ISSUE	RESPONSE
Sydney Olympic Park Authority	
<p>SOPA Act & Environmental Guidelines</p> <p>The application does not include any assessment of consistency with the SOPA Act 2001 or SOPA's Environmental Guidelines. The SOPA Act (s22(2)) requires that <i>'in determining an application for consent to carry out development on land within Sydney Olympic Park, the Minister for Urban Affairs and Planning must consider the consistency of the proposed development with the Environmental Guidelines'</i>.</p>	<p>The Addendum to SOPA's submission identifies the relevant clauses of the Environmental Guidelines. these are addressed in the Addendum - Stormwater section of this table.</p>
<p>Stormwater</p> <p>The proposed development site is outside the WRAMS catchment area, and stormwater from this site cannot be readily harvested into WRAMS, however no other solution to stormwater collection and recycling (e.g. harvesting for reuse with the development) appears to have been considered in project design. All stormwater is proposed to be discharged to Bennelong Pond, and this is considered to be inconsistent with the Environmental Guidelines (Refer to Point 1 of the Addendum).</p> <p>Stormwater har

Drawing Title
THE CHASE -
DETAIL PLAN

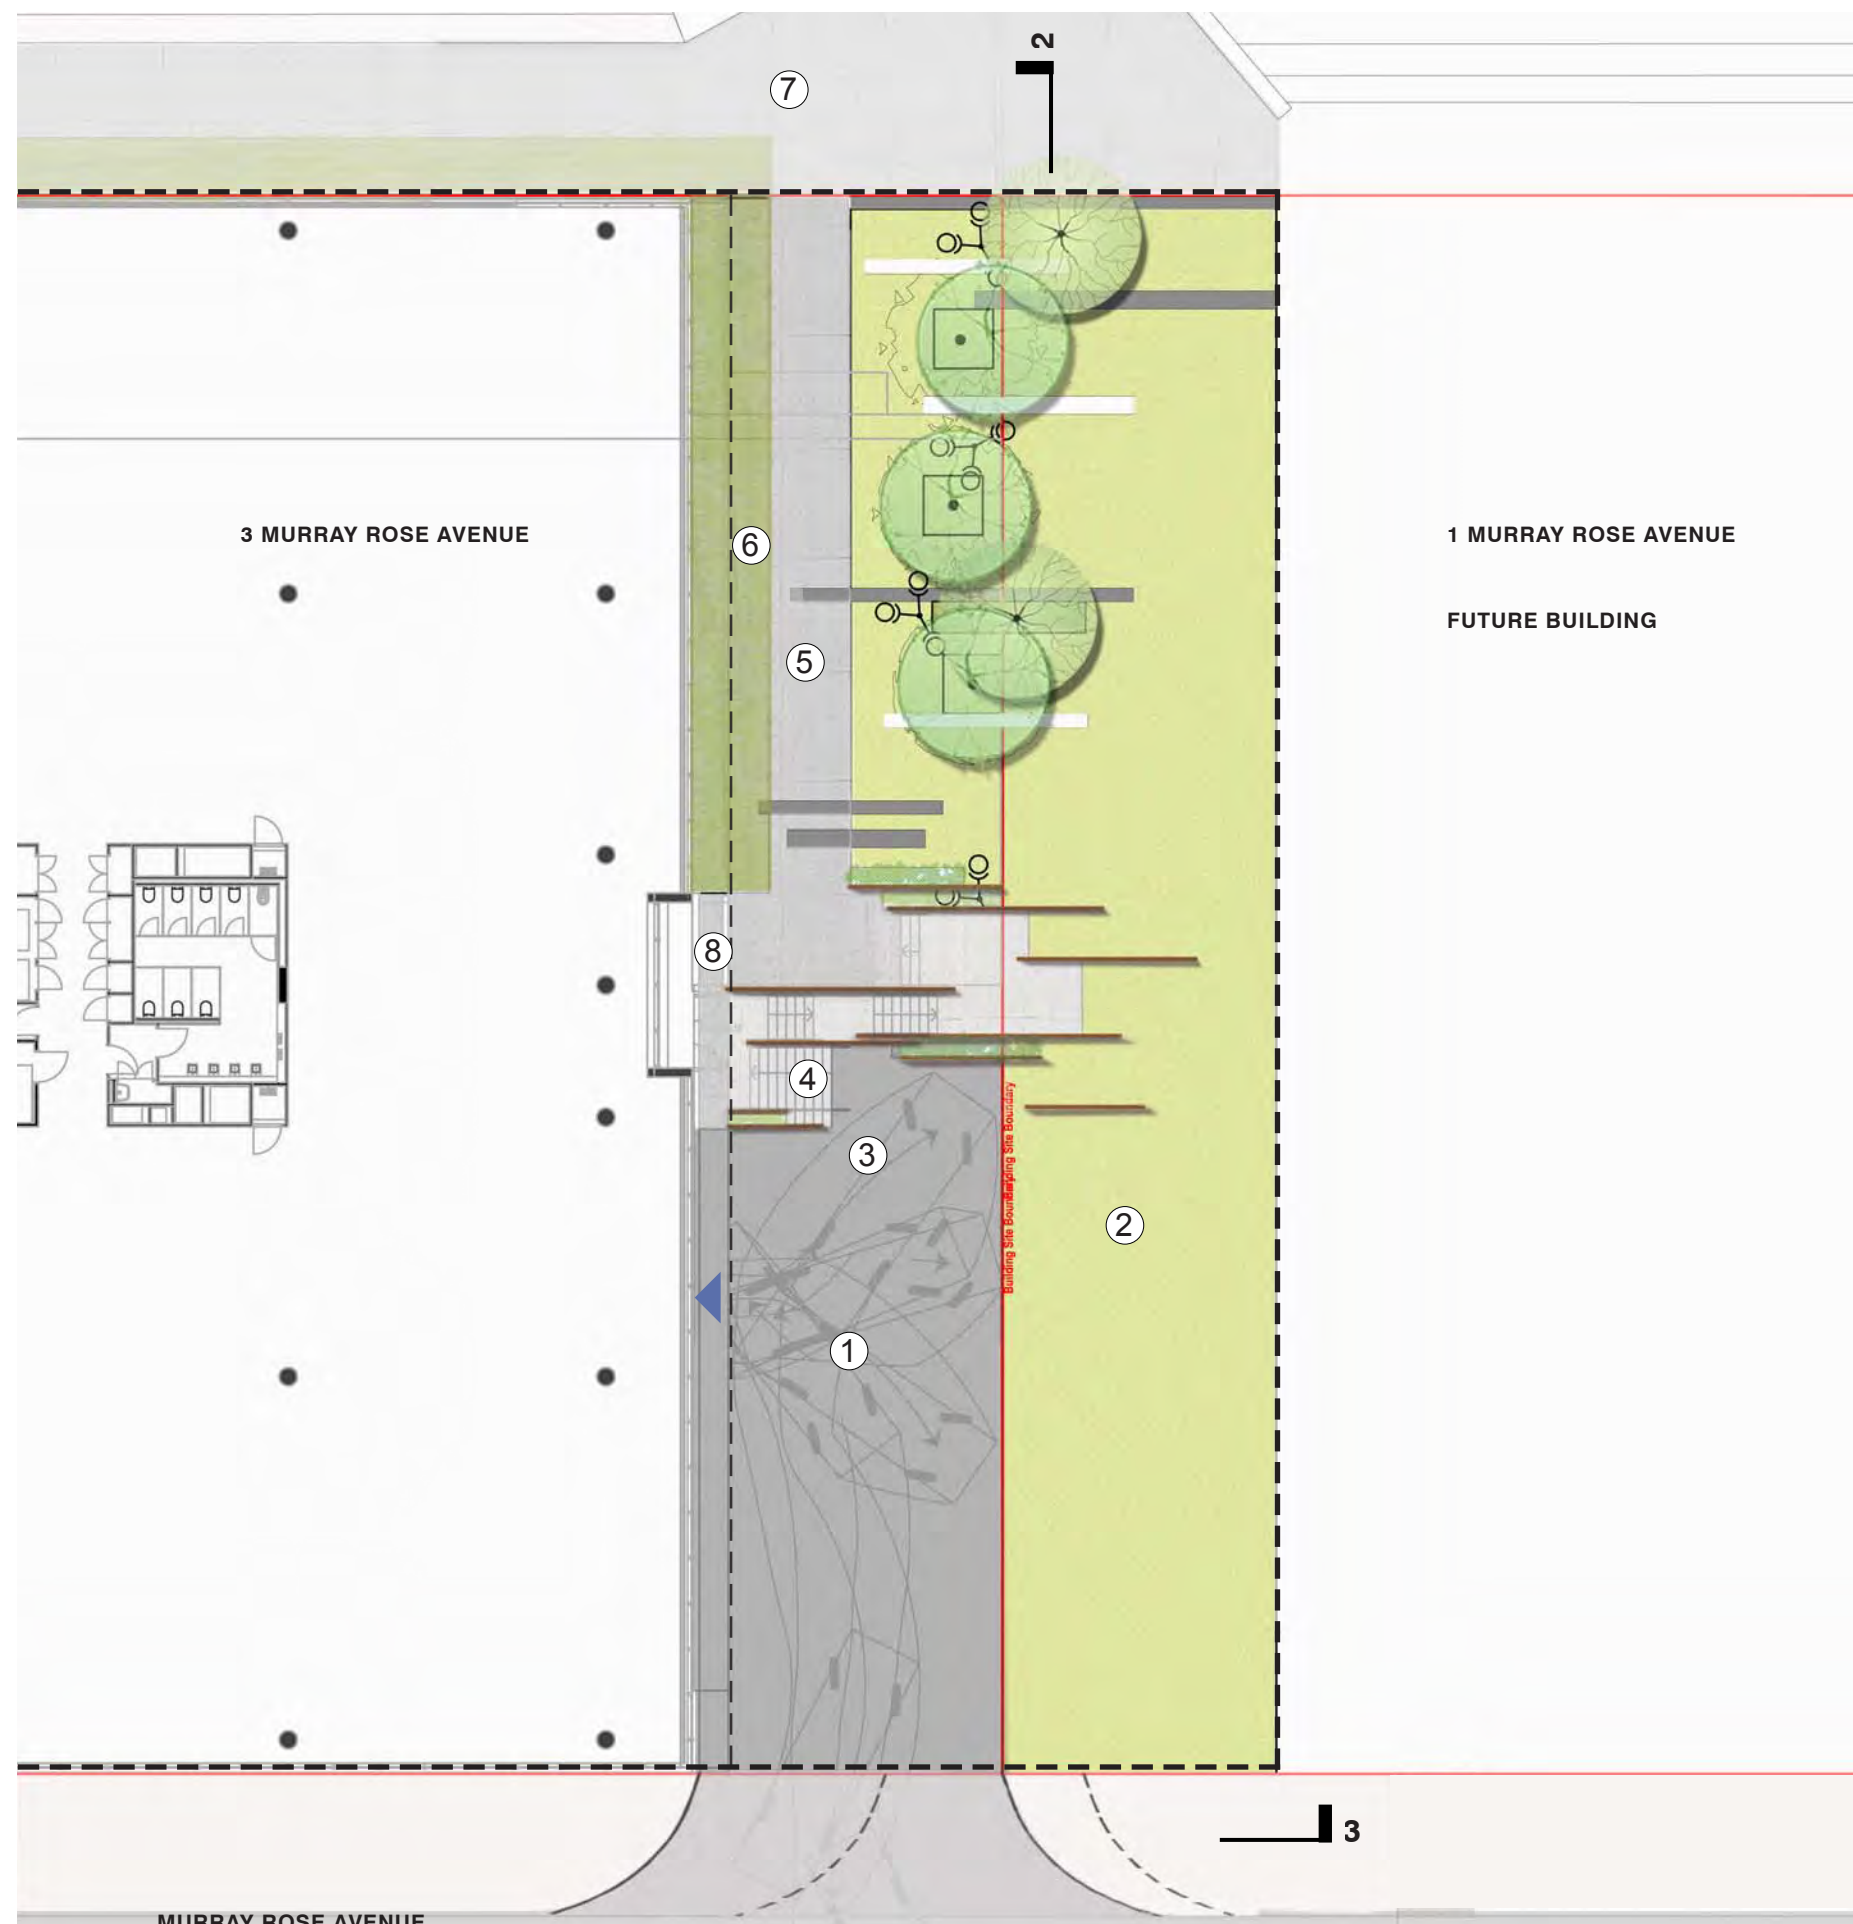
ISSUE	RESPONSE
<p>this matter in more detail.</p> <ul style="list-style-type: none"> The pedestrian path within "the Chase" is shown as 1.2m wide and not consistent with the Authority's Access Guidelines which nominate 1.8m as the minimum width for publicly accessible paths. The SOPA Access Guidelines (May 2011) are to be Implemented as the minimum standard. It is not clear if there is provision for deep soil zones / pockets to support trees proposed over "the Cutting". This is also applicable to trees proposed within "the Chase" as Drawing EA301.G indicates a plant room/service zone under the roadway with no allowance for deep soil zones/pockets to support future tree planting shown on Drawing LA6D. The proponent should prepare a Landscape Plan with cross sections (showing minimum 1m depth tree planting pockets, root-able soil volumes and irrigation system) for SOPA's approval. 	<p>SOPA Access Guidelines.</p> <p>Deep soil zones are provided in the area adjacent to Murray rose Avenue in the Cutting and adjacent to Brick Pit Park in the Chase. These are not over any structure and so will be able to support large trees. The planting near Murray Rose Avenue in the Chase is nominated on the landscape drawings as "stepped entry planting accentuating laneway design" and does not require deep soil zones.</p>
